CITY OF ALBUQUERQUE

November 29, 2007

Re: Tract 8 West bluff Center, Traffic Circulation Layout
Engineer's Stamp dated 11-28-07 (H-11/D059C)

ENGINEER'S SEAL	WESTSIDE RETAIL	DRAWN BY DFT
	TRAFFIC CONTROL LAYOUT	DATE 10-23-07
	TERRA WEST, LLC 5571 MIDWAY PARK PLACE NE ALBUQUERQUE, NM 87109 (505)858-3100	SHEET # 2739
	RONALD R. BOHANNAN P.E. #7868	JOB # 27039

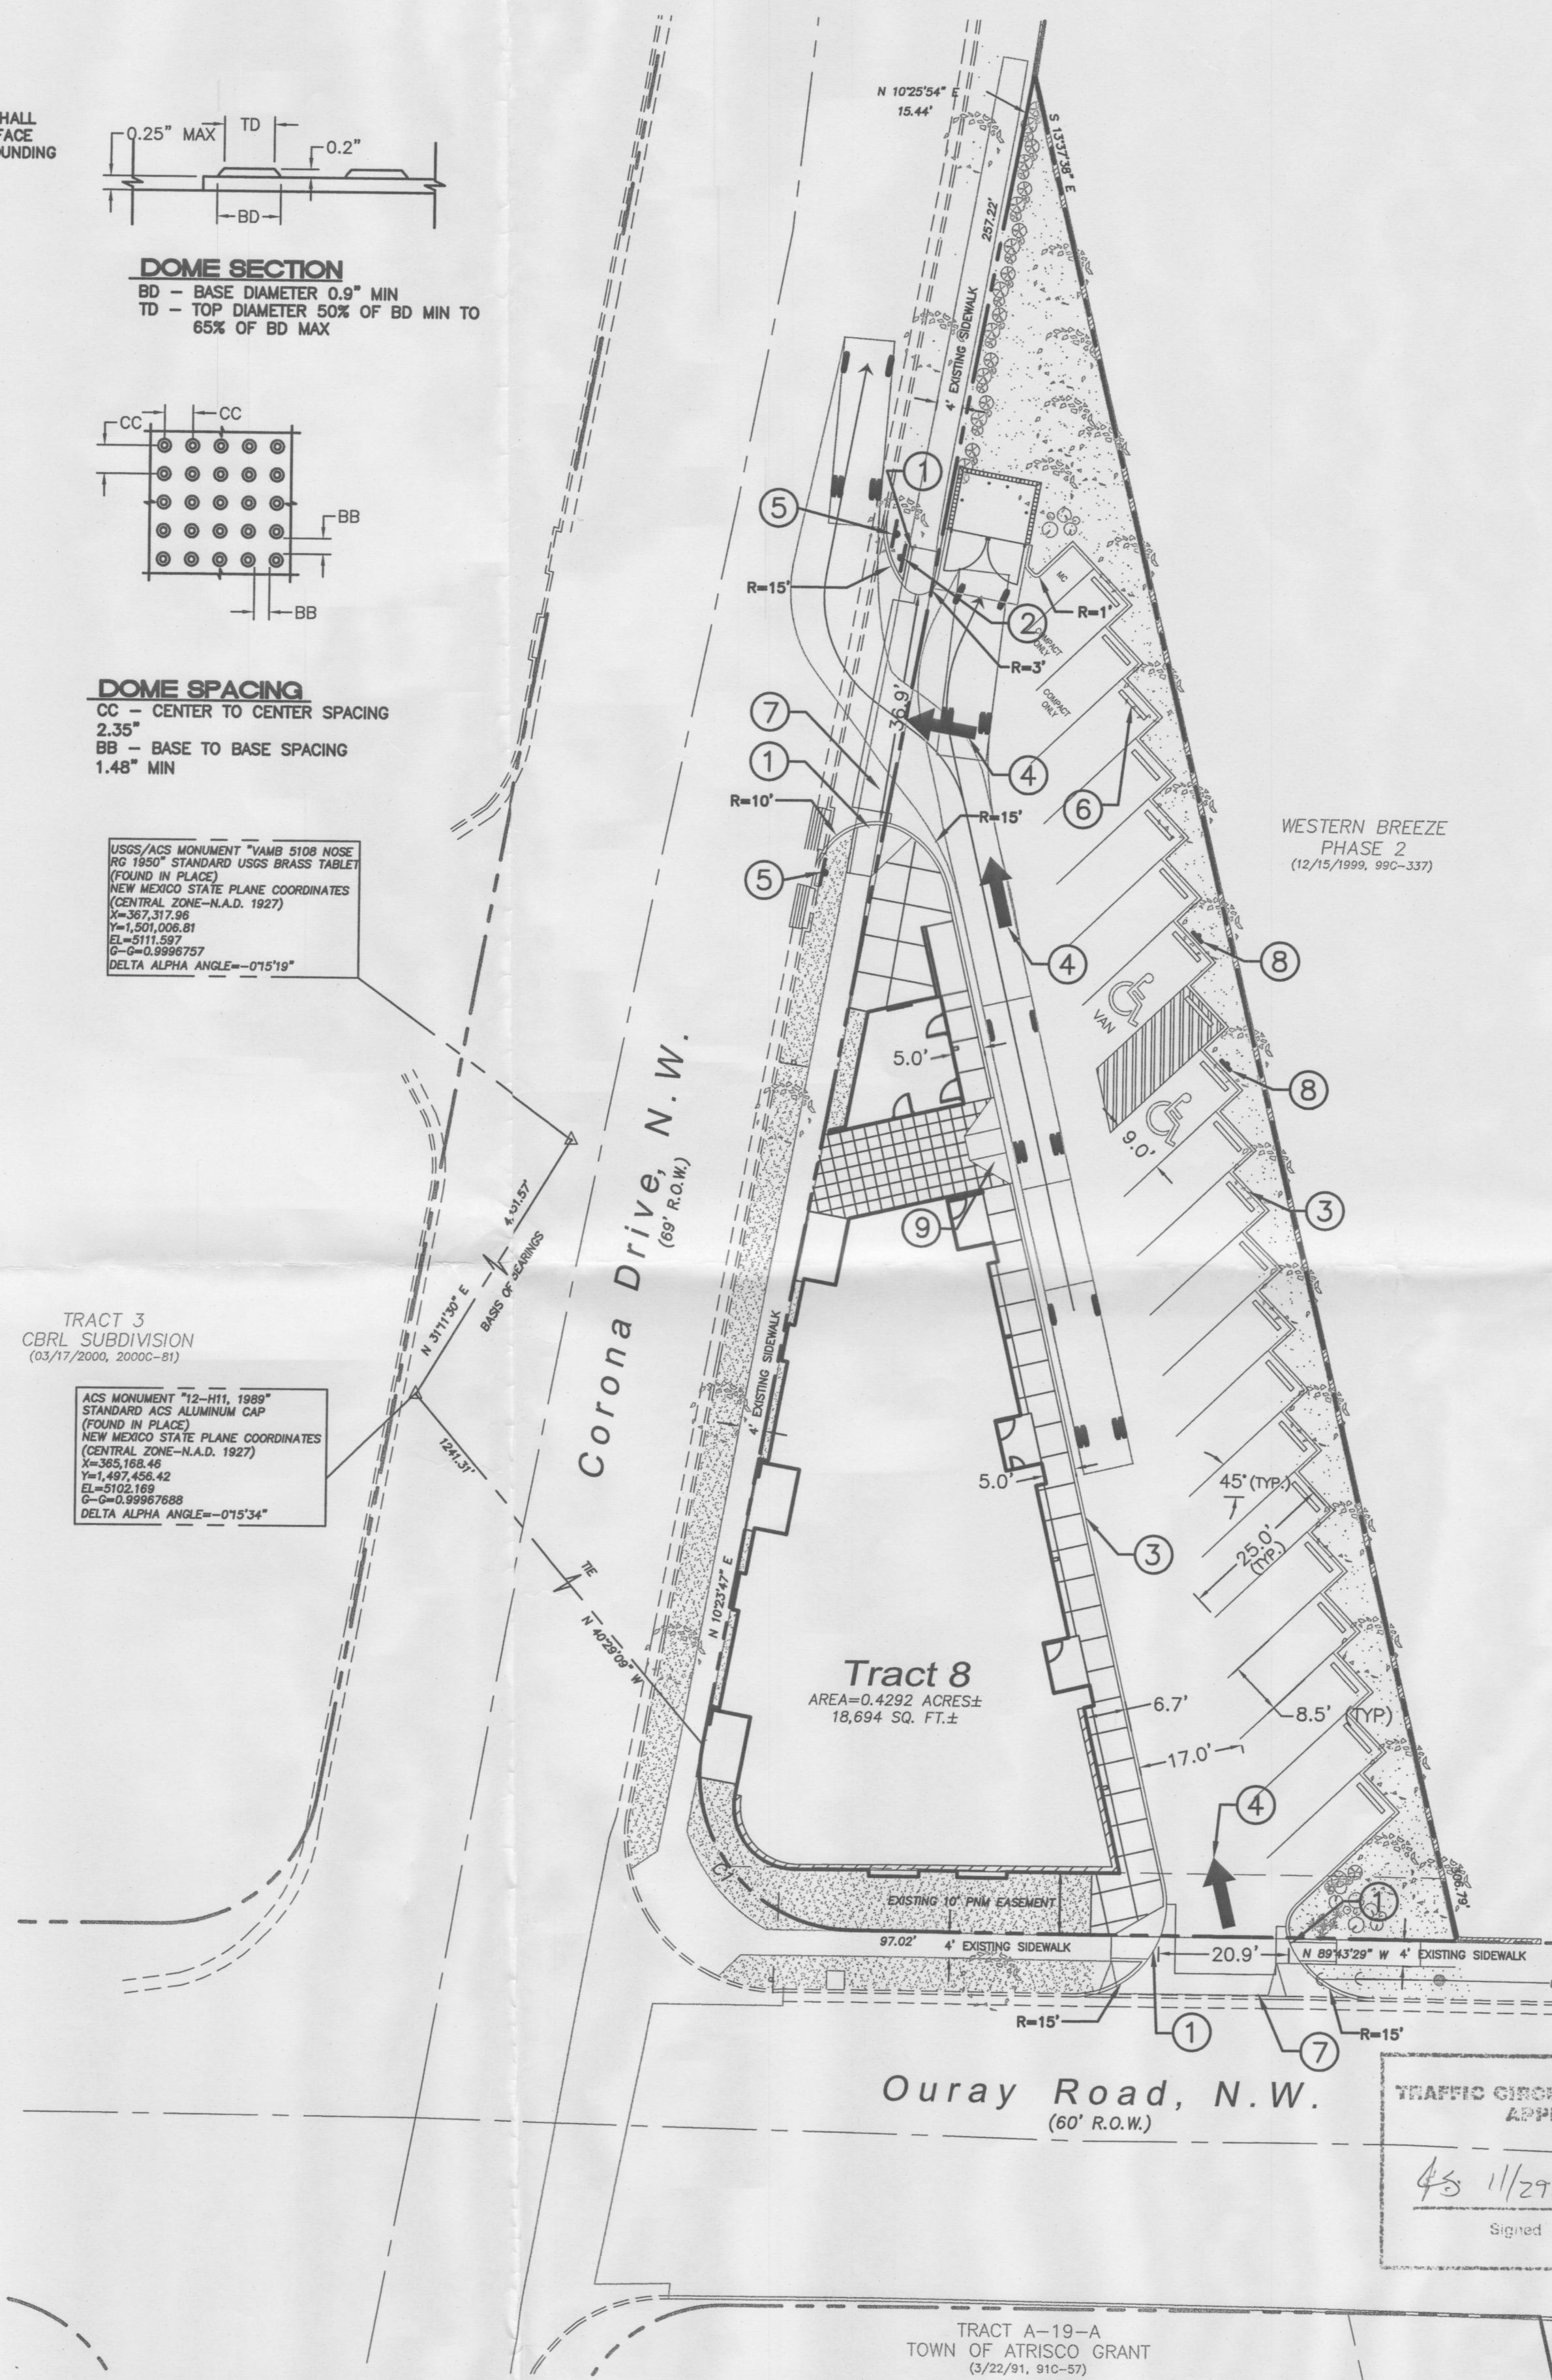
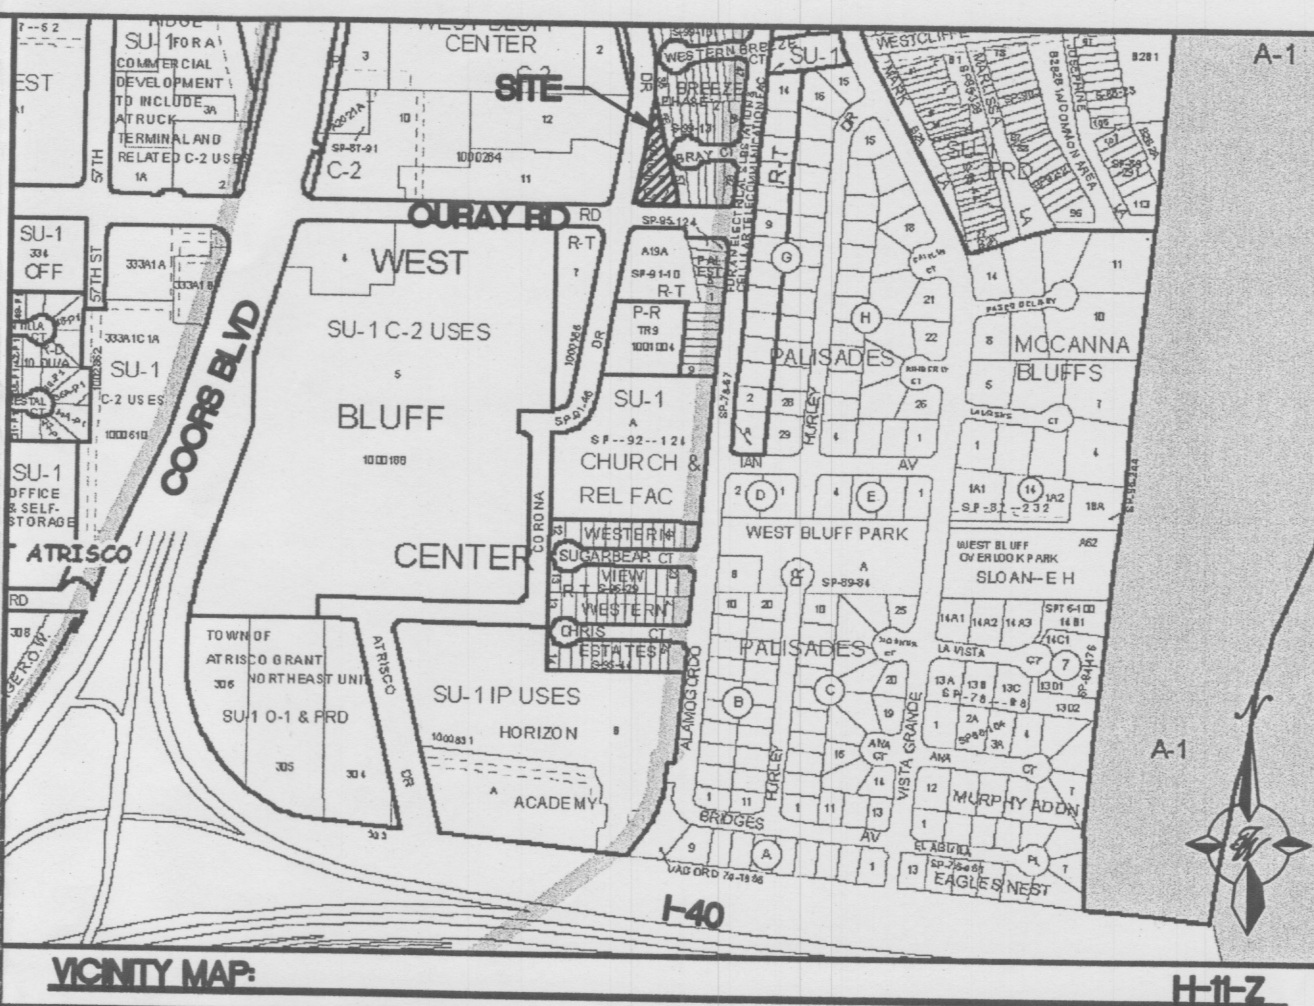
The TCL submittal received 11-29-07 is approved for Building Permit. The plan is stamped and signed as approved. A copy of this plan will be needed for each of the building permit plans. Please keep the original to be used for certification of the site for final C.O. for Transportation. **Public infrastructure or work done within City Right-of-Way shown on these plans is for information only and is not part of approval. A separate DRC and/or other appropriate permits are required to construct these items.**
